**KIRKLEES METROPOLITAN COUNCIL
INVESTMENT & REGENERATION SERVICE**

DELEGATED DECISION TO DETERMINE PLANNING APPLICATIONS

Reference No:	2022/62/91839/W
Site Address:	7, Gatesgarth Crescent, Lindley, Huddersfield, HD3 3LG
Description:	Erection of two storey side extension
Recommending Officer:	Tom Hunt

Officer Report

Dwg. no.	Rev.
117-22-PL02	C

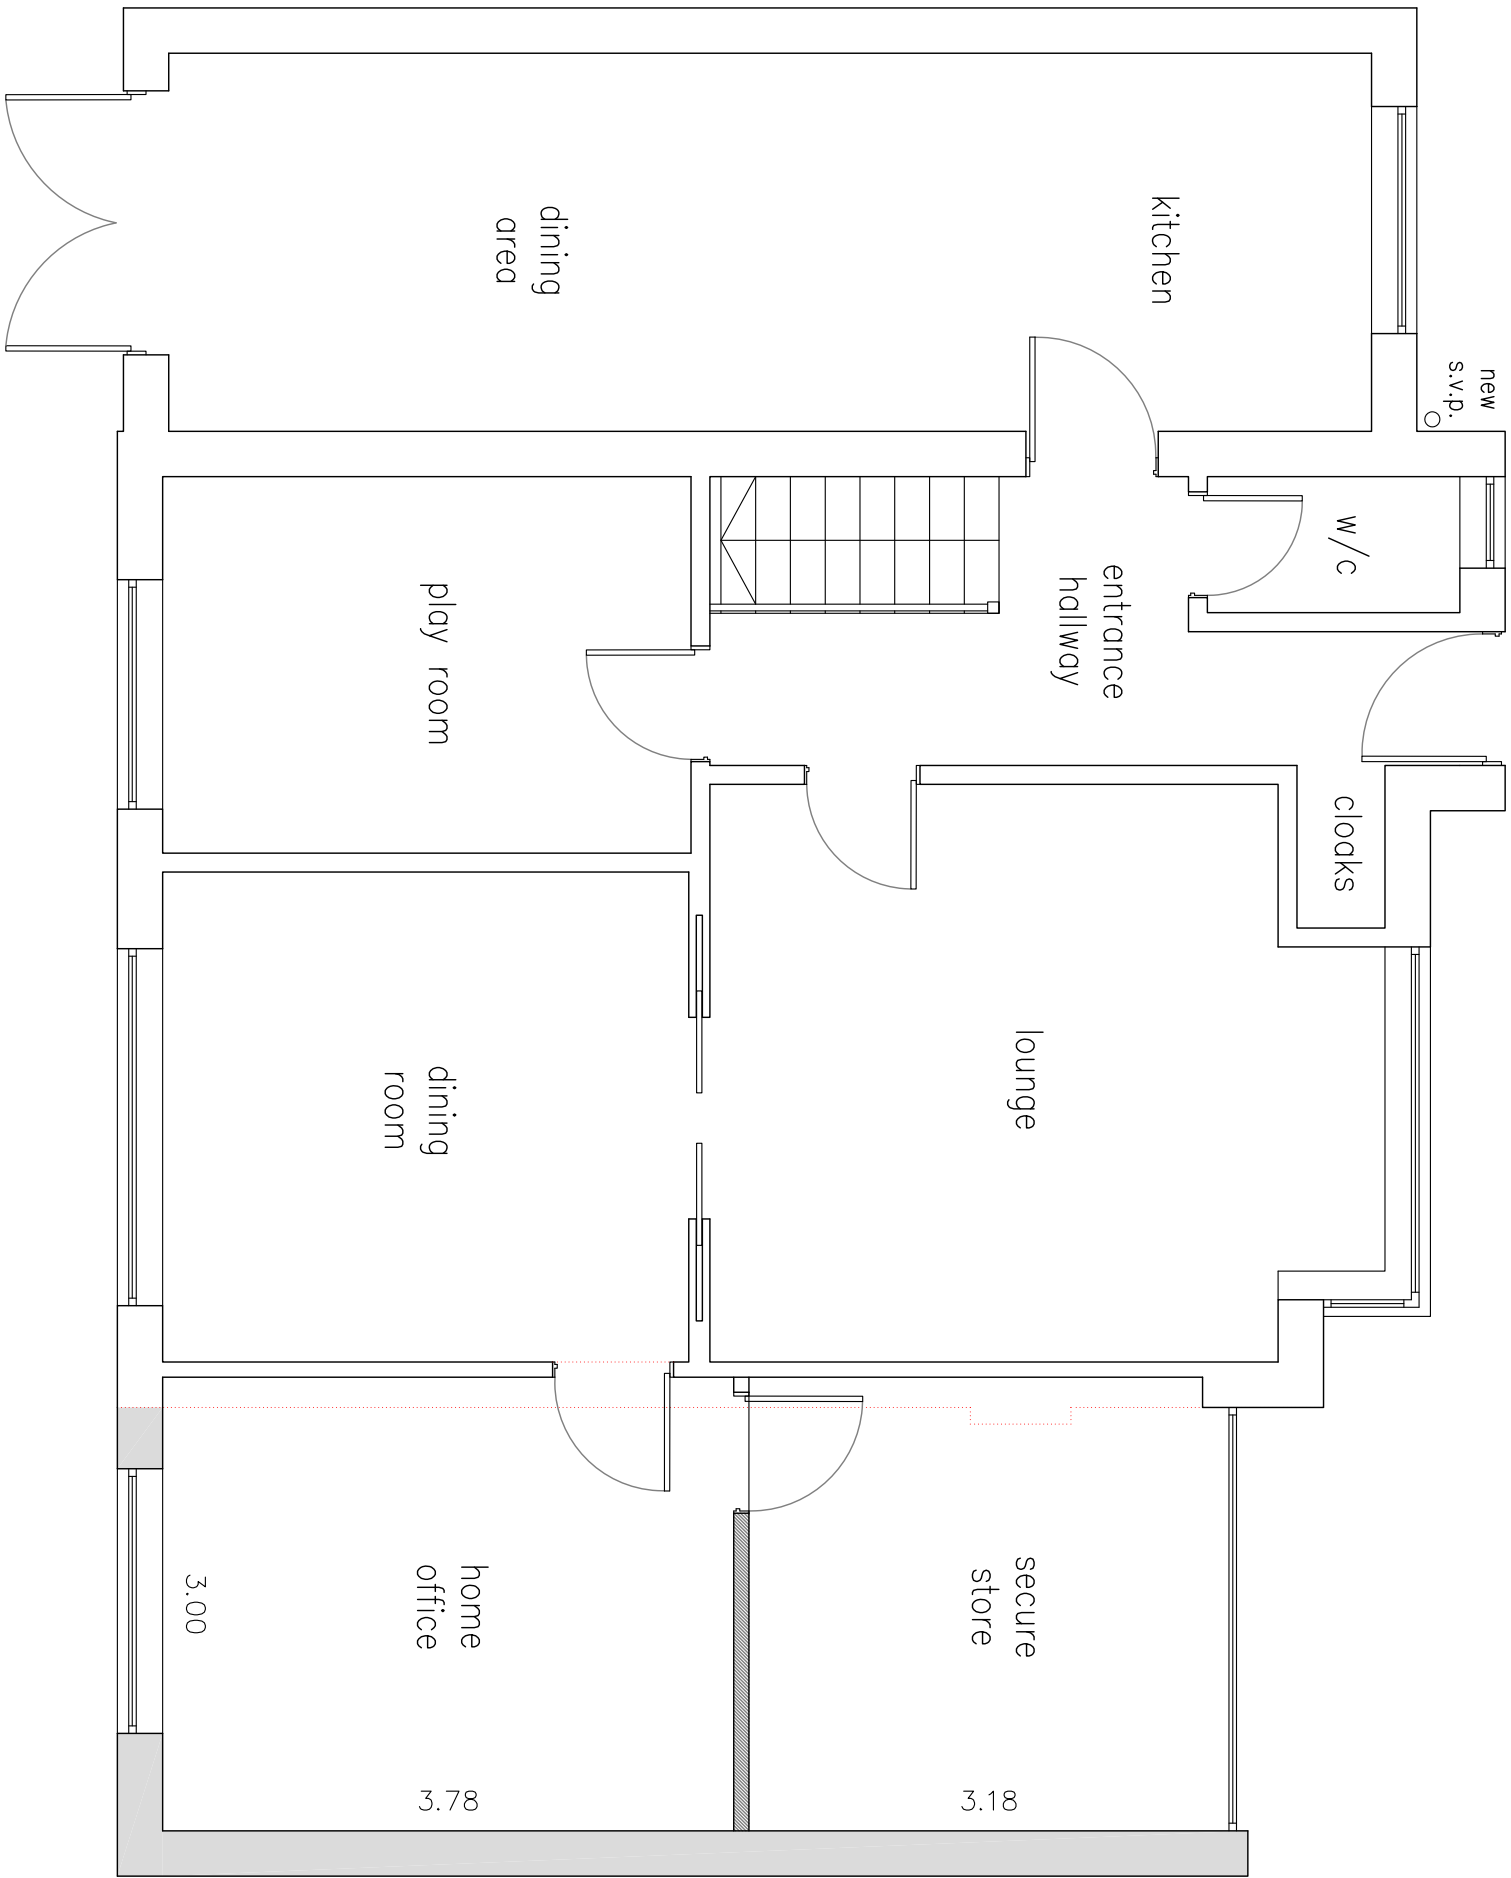
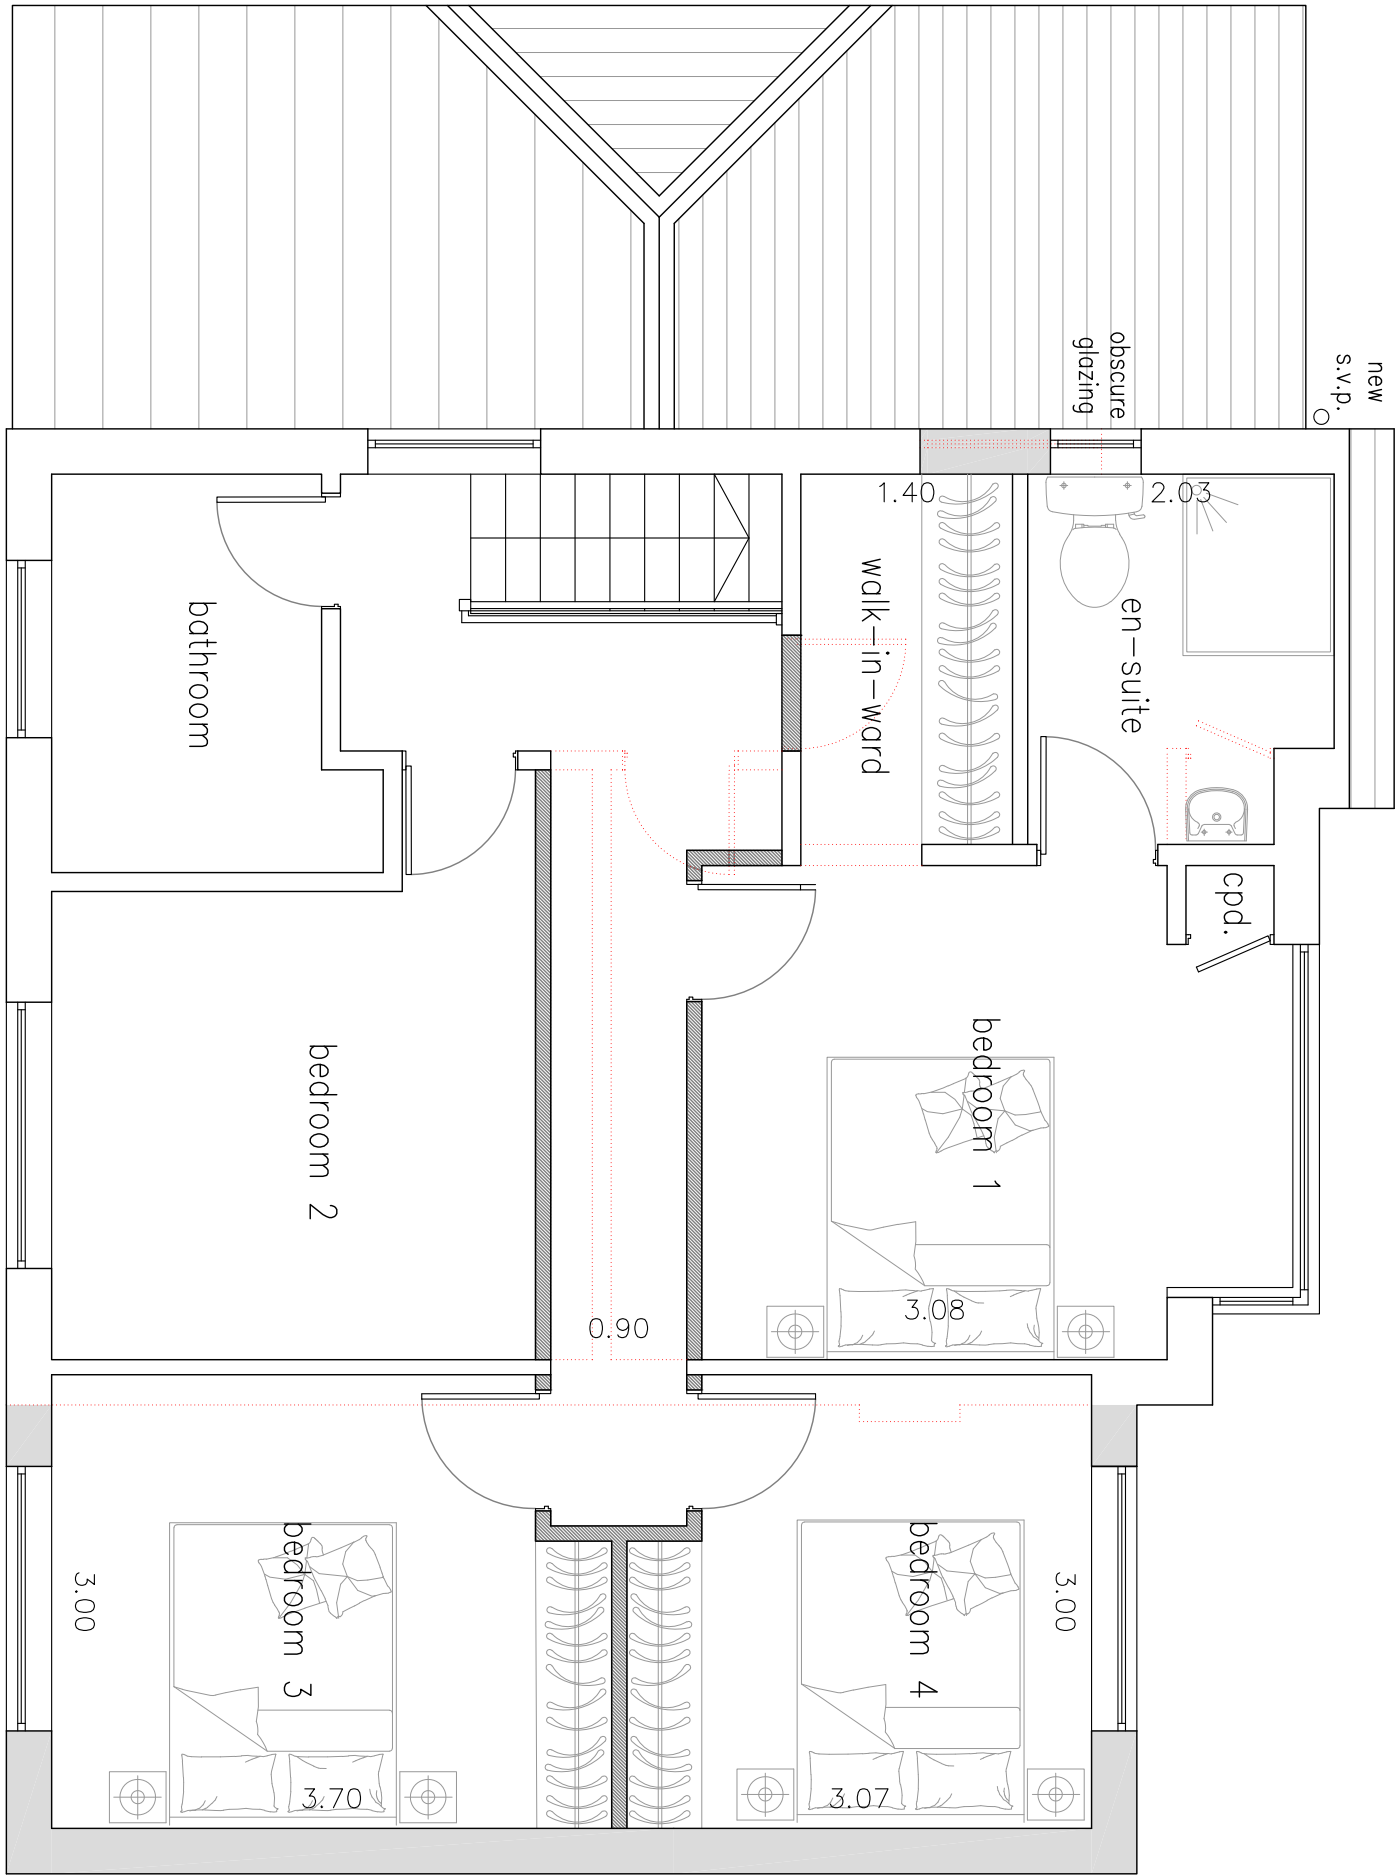
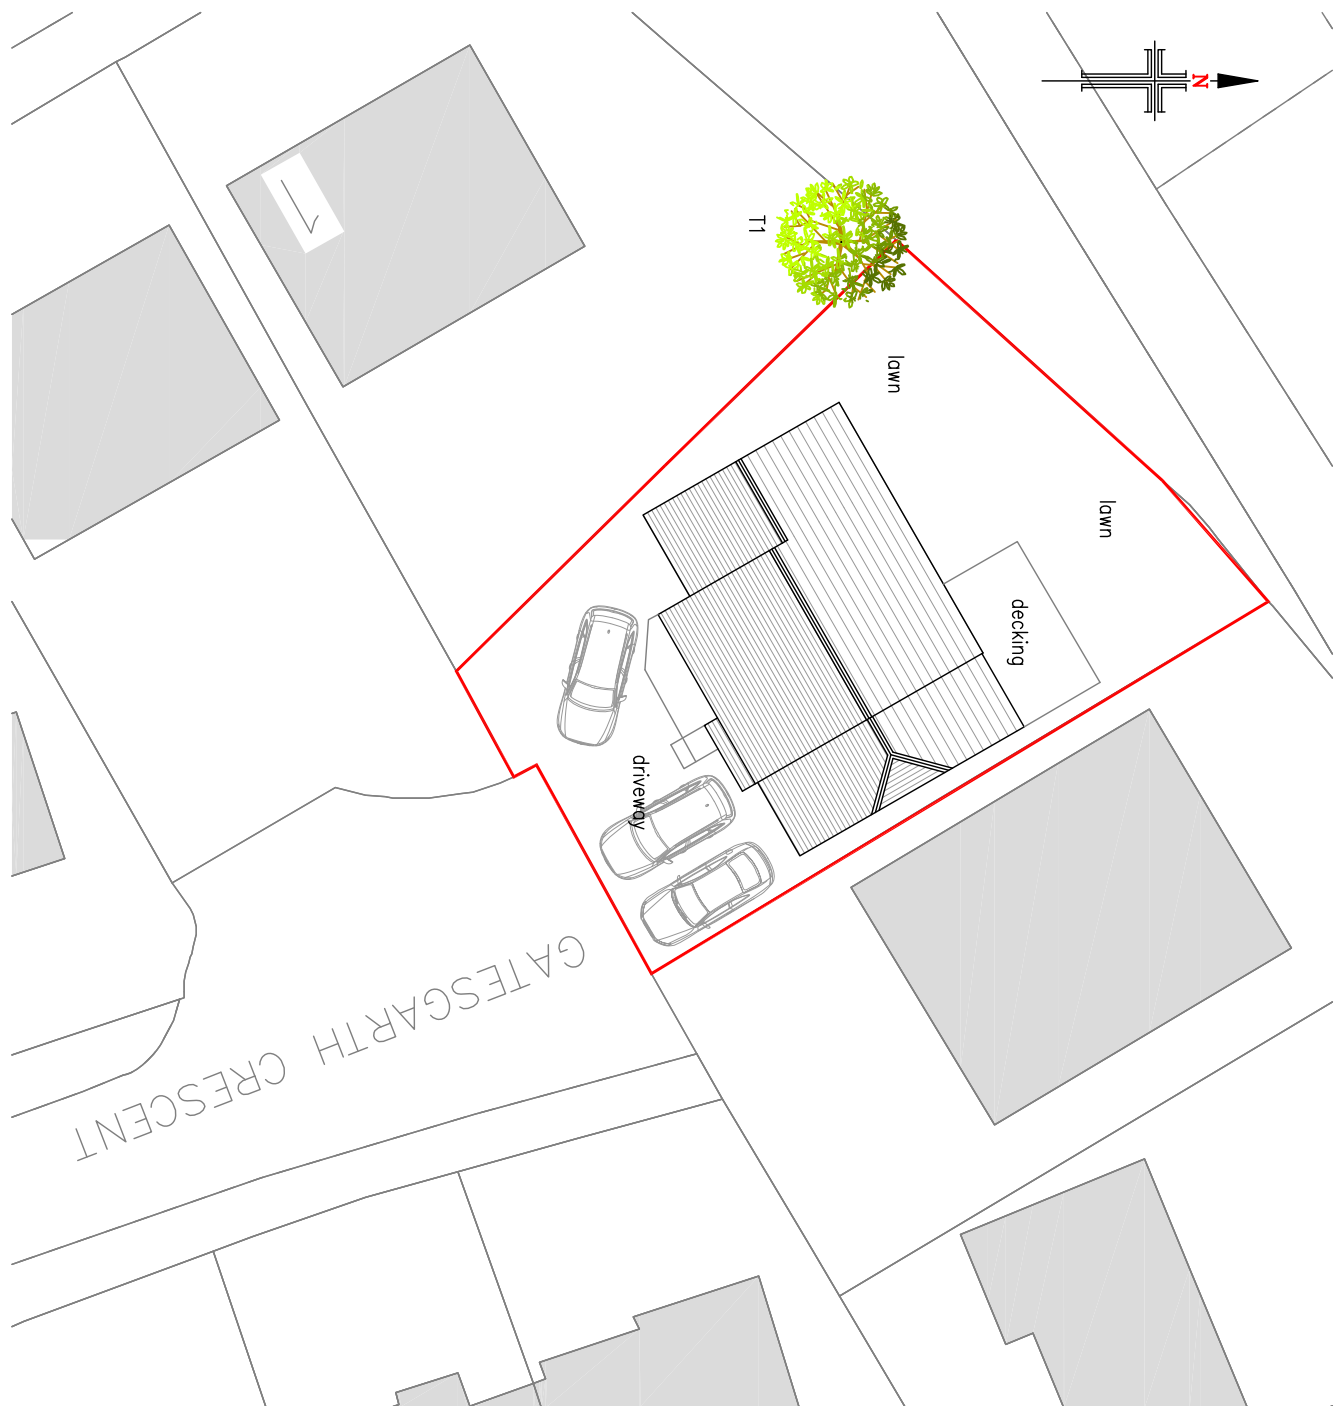
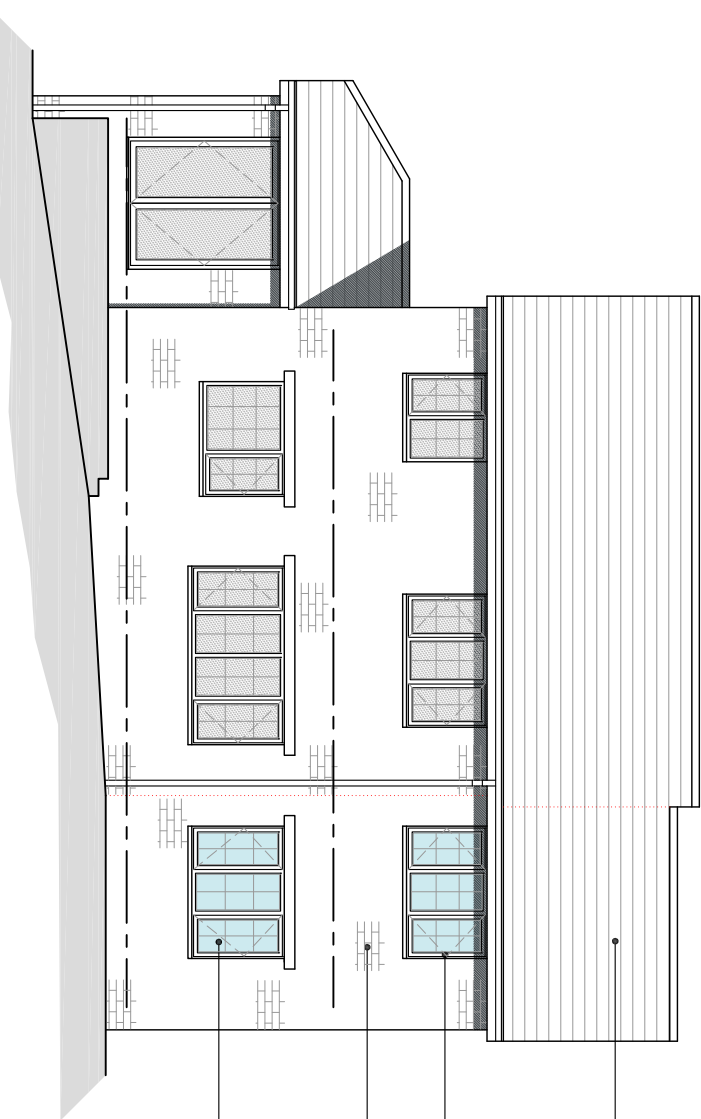
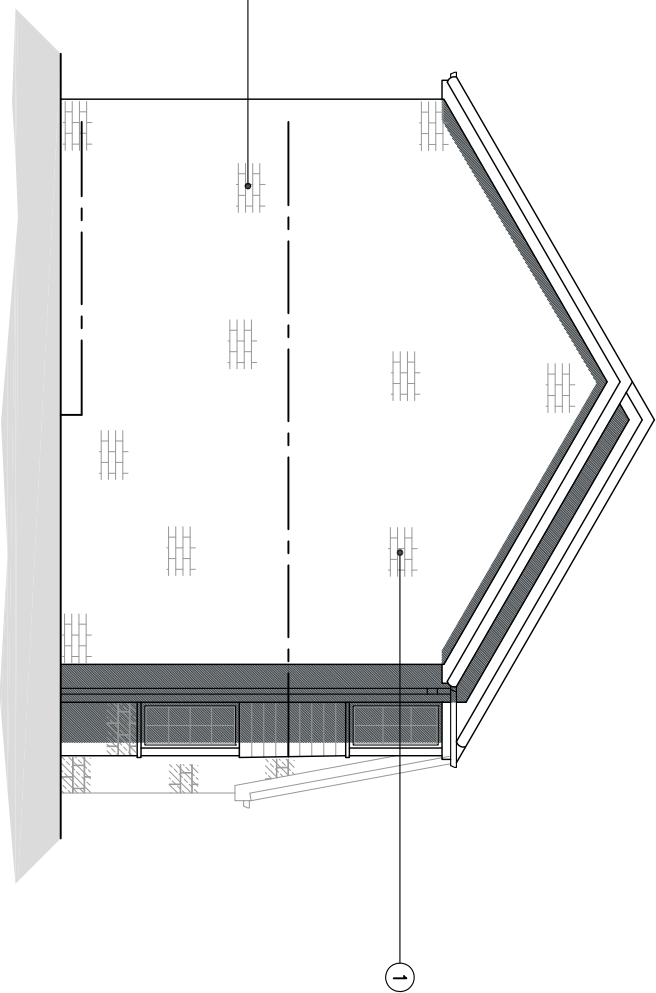
The proposed would be within a broadly wedge-shaped plot to the side of the host with there being a gap of ~0.7m-2.6m to the flank plot boundary. This would be within the established flank elevations to flank plot boundary shown within the streetscene and would not appear out of keeping whilst retaining a gap. To have a wedge shaped extension to maintain a full 1m gap would appear incongruous with the form of the dwelling and streetscene design. It is also considered that given there is no side wall adjacent to this extension, the separation from the boundary would be sufficient to prevent a terracing effect or the development appearing cramped on the site. The extension would be set back ~0.6m from the main body of the house set behind the bay window extension enabling the property to meet the design guidance set out in the SPD.

The two storey side extension would be set down from the host dwelling's roof ridge and set back from the main body of the dwellinghouse and be of modest width and projection aiding in the extension's scale appearing broadly subservient to the main dwelling. It would have low embodied energy materials and detailing to match the host with a side gable roof to the host's own side gable roof enabling the design to be a cohesive and harmonious addition.

For a 4 plus bedroom dwelling, it should have three off street parking spaces. Currently three are indicated within the application site at the end of the close on plans. Whilst the indicated cars on plans submitted are 2m by 4.6m approximately which is under the 2.4m by 5m sought by Officers, there appears to be more than sufficient space to provide off-street parking spaces for at least two cars. There are regular bus links to Huddersfield within 3 minutes walk and to the nearest centre at Lindley which is within reasonable walking distance towards Lindley albeit down a steep slope in good conditions. The undersupply of parking for three cars can reasonably be supported by the frequent public transport links to centres and access to services.

4. Prior to the hereby approved extension being first brought into use, two parking spaces measuring a minimum of 2.4 metres wide by 4.8 metres long shall be provided within the site outlined in red on the hereby approved 'Proposed Floor Plans, Elevations and Site Plan. Drawing No. 117-22-PL02. Revision: C.' The spaces shall be laid out with a hardened and drained surface in accordance with the Communities and Local Government; and Environment Agencies 'Guidance on the permeable surfacing of front gardens (parking areas)' published 13th May 2009 (ISBN 9781409804864) as amended or any successor guidance. Notwithstanding the provisions of the Town and Country Planning (General Permitted Development) Order 2015 as amended (or any Order revoking or re-enacting that Order) these areas shall be so retained, free of obstructions and available for the parking of vehicles.
